RFI ITEMS

BCD Recommendations	RFI Response Comments										
1. The comments on coastal issues provided by BCS on 27 May 2021 be addressed.	We understand the comments relating to coastal issues provided by BCS on 27 th May 2021 relate to addressing Clause 13 and Clause 14 of SEPP (Coastal Management) 2018.										
	SEPP (Coastal Management) 2018 has now been repealed and its provisions rolled into SEPP (Resilience and Hazards) 2021. The equivalent provisions to Clause 13 and Clause 14 of SEPP (Coastal Management) 2018 within SEPP (Resilience and Hazards) 2021, are Clause 2.10 and Clause 2.11.										
	Importantly we note that most of the project site is clear of the Coastal Use Area and the Coastal Environment Area. In the north-western corner of the site an irregular lot boundary partially intersects the Coastal Use Area and Coastal Environment Area. Further, only a relatively small area of Phase 11 (estimated as some 23,905m ²) falls within the Coastal Environment Area. Refer Attachment 2 – G&S Response Letter dated 28 th May 2025 for the location of the Coastal Use Area and Coastal Environment Area as it relates to the site and extract areas.										
	Clause 2.10 and Cla

TITLE
LAKE BANK PROFILE LAYOUT
 SCALE
 1:6000 AT A1
 1:12000 AT A3

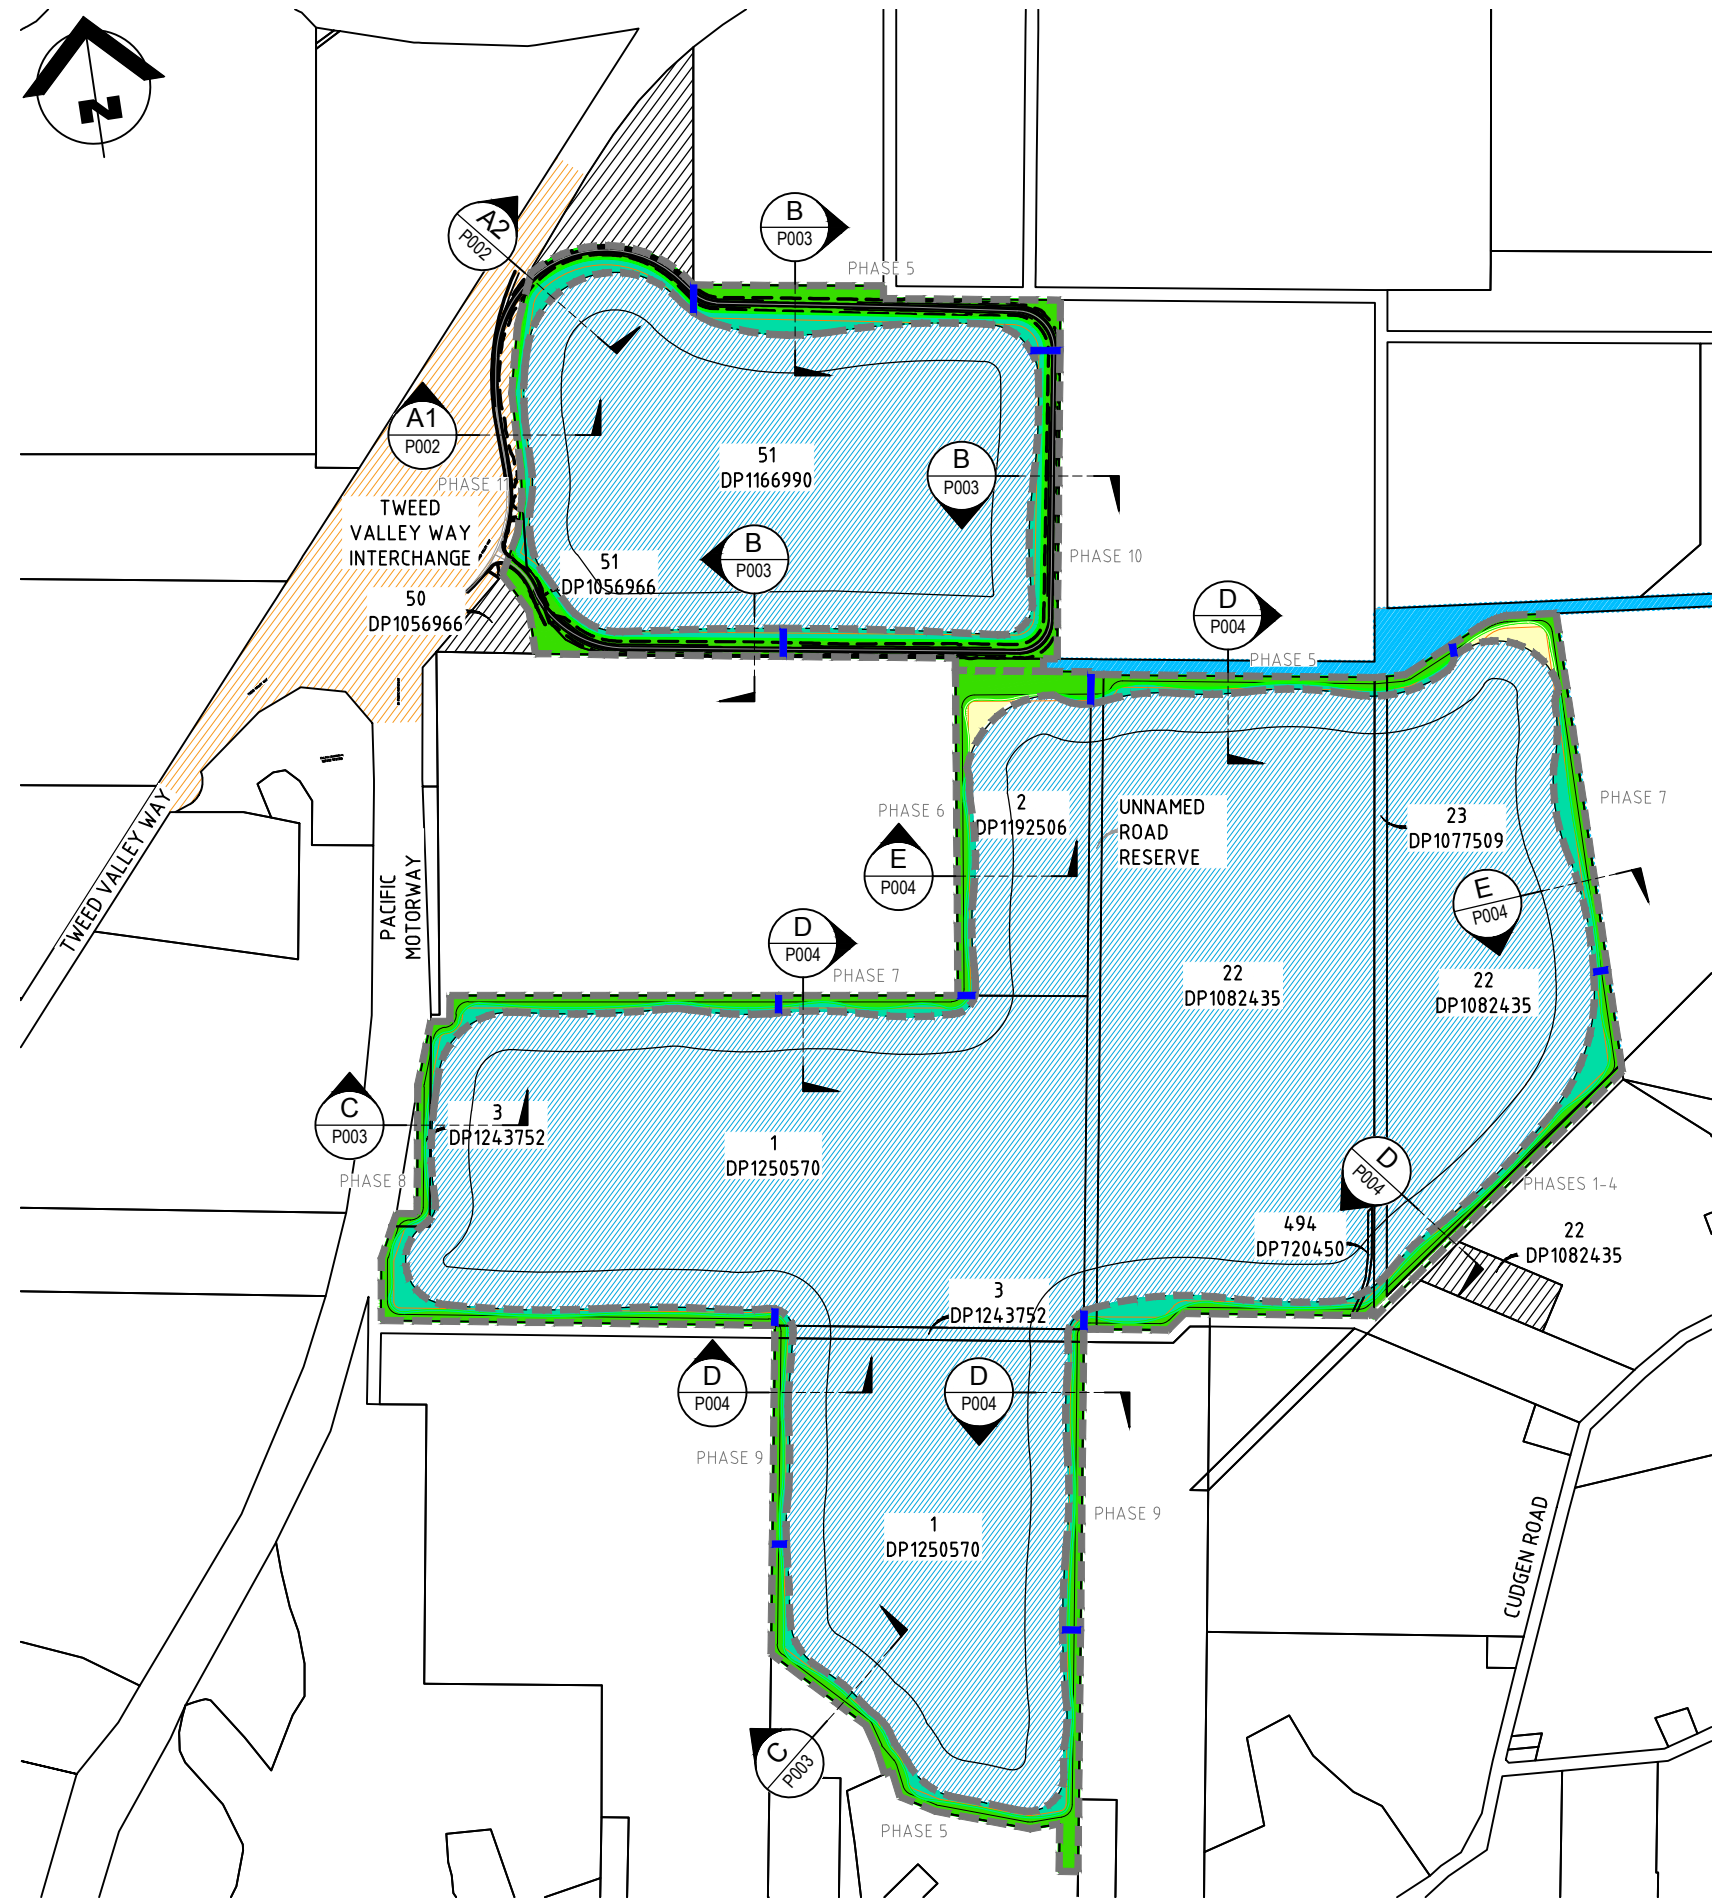
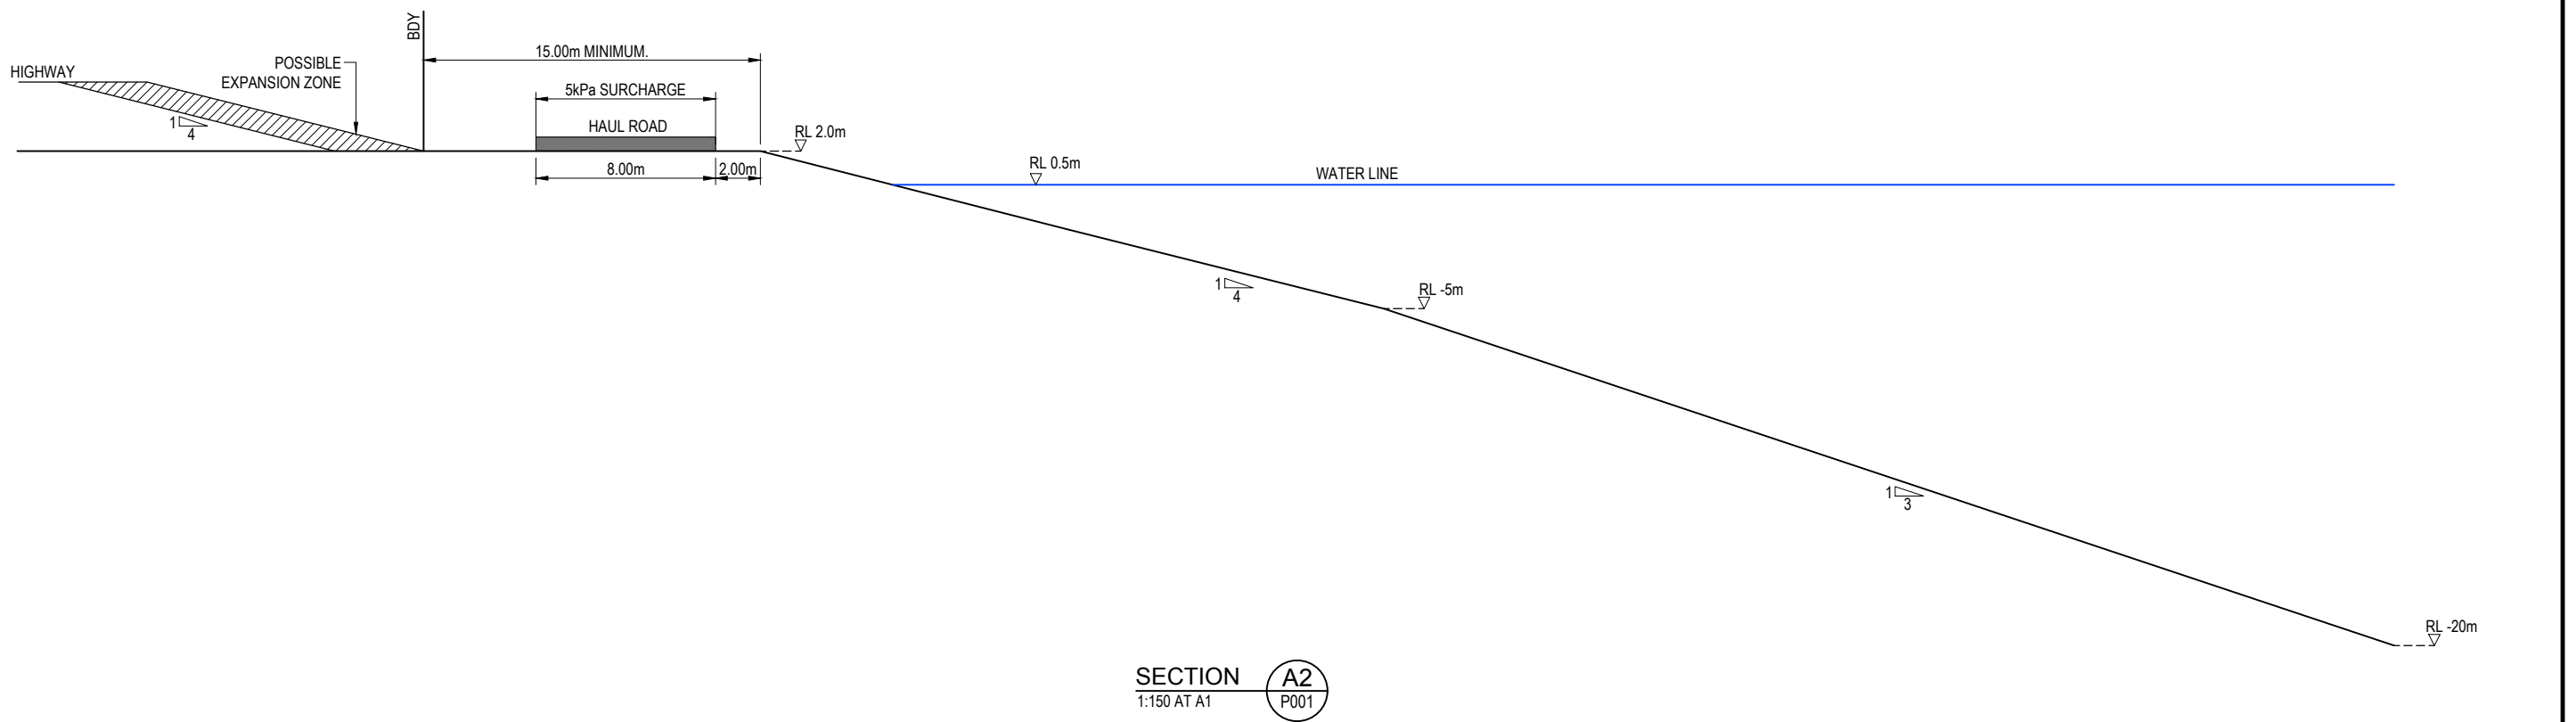
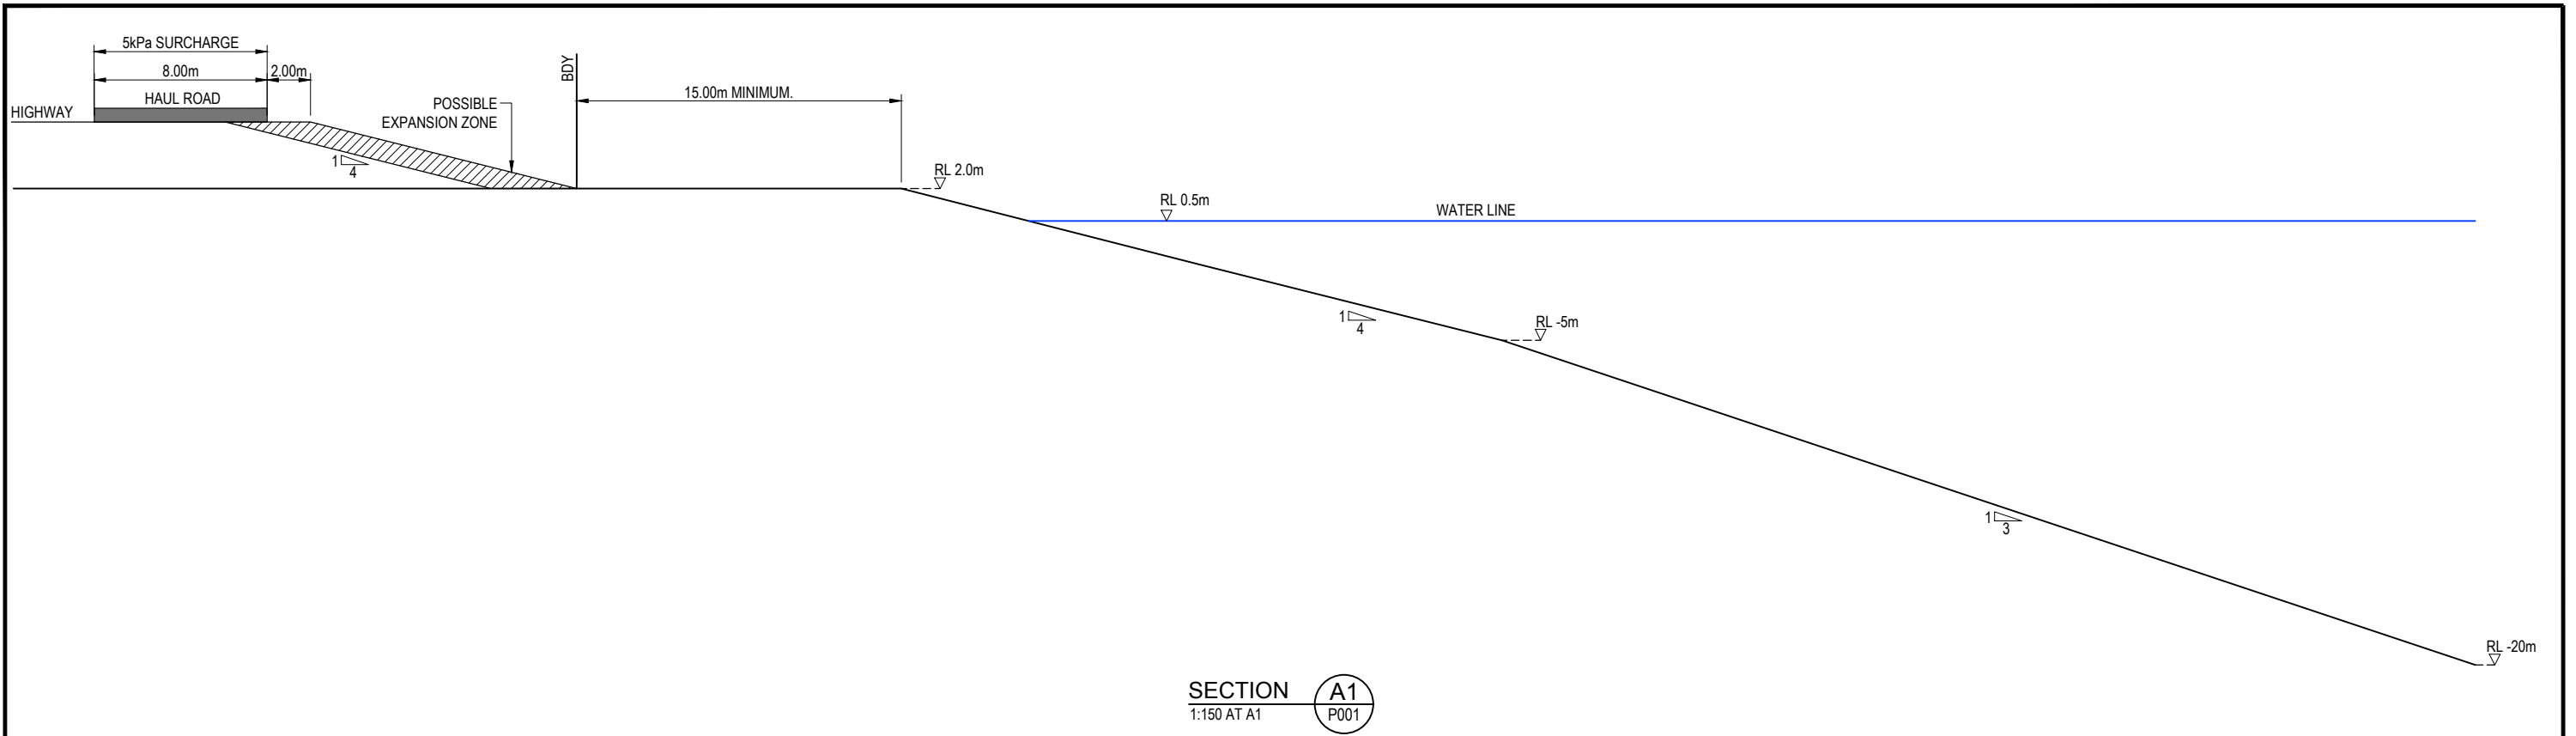
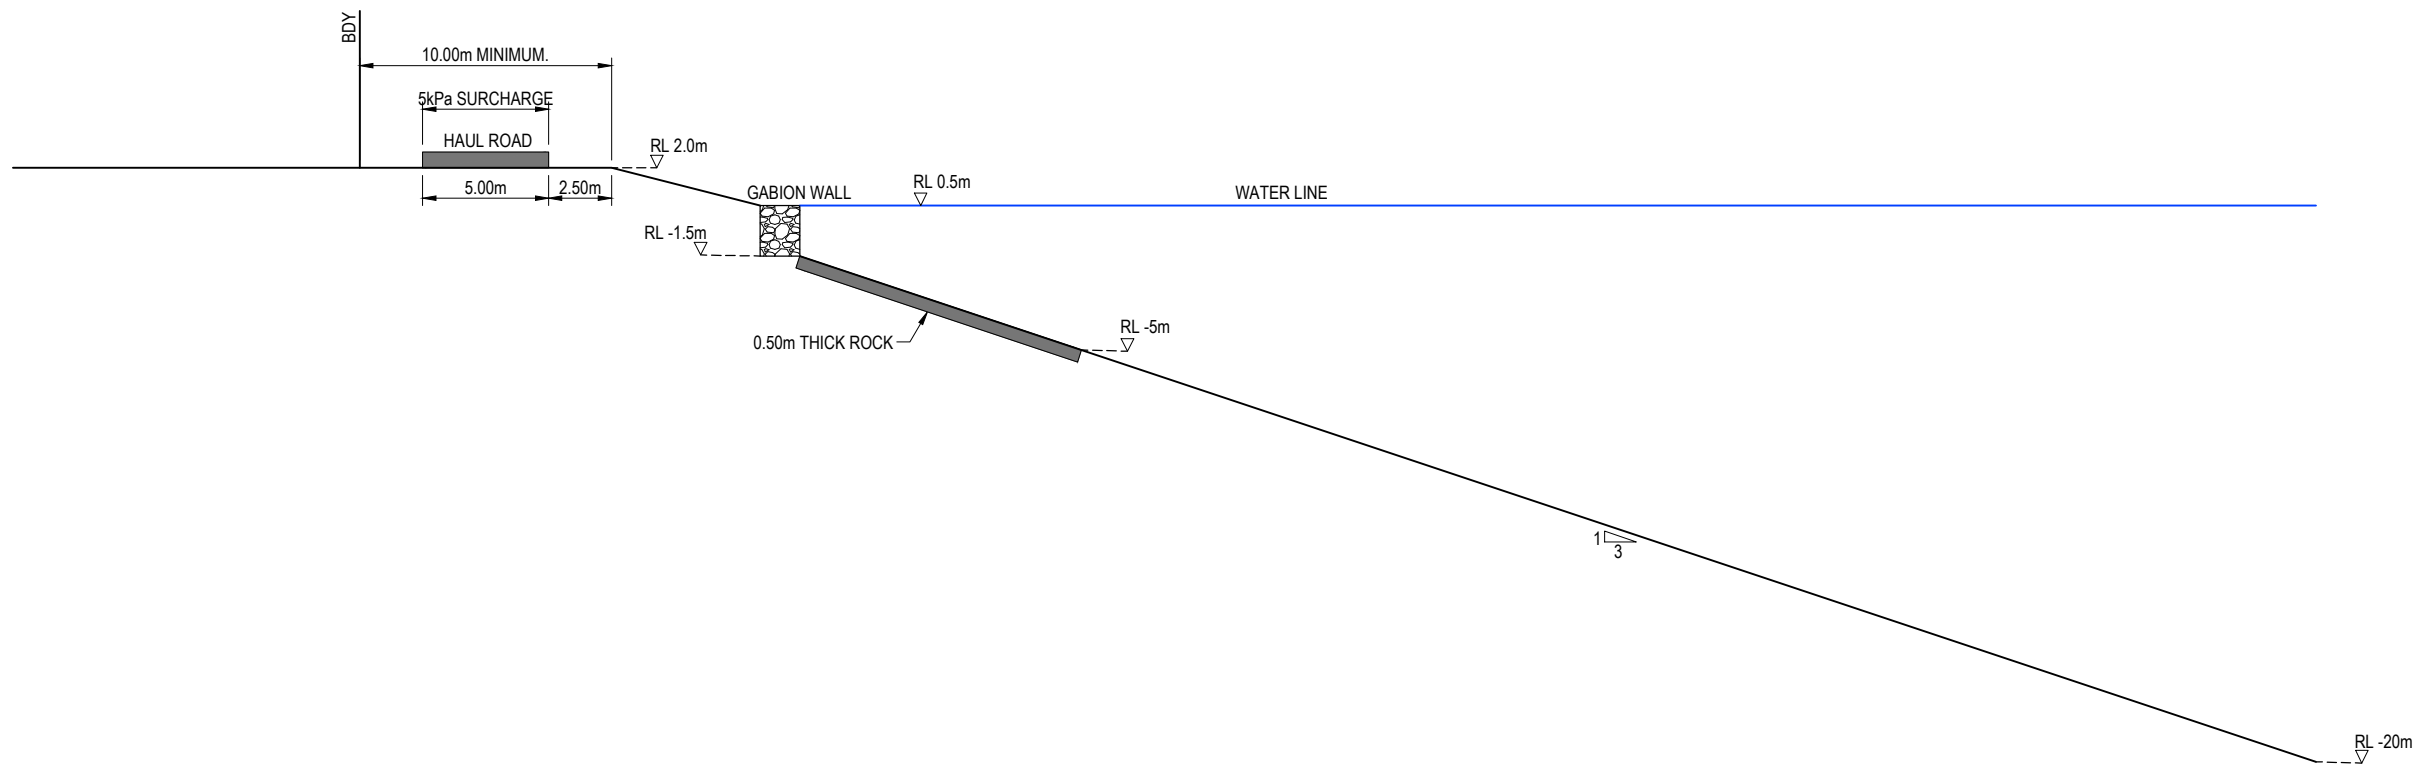
11. Appropriately scaled and dimensioned plans and sections be provided that demonstrate what will be achieved for the rehabilitation works both for the riparian area and wetland area.	Please refer to Attachment 8 – Revised Lake Bank Profiles
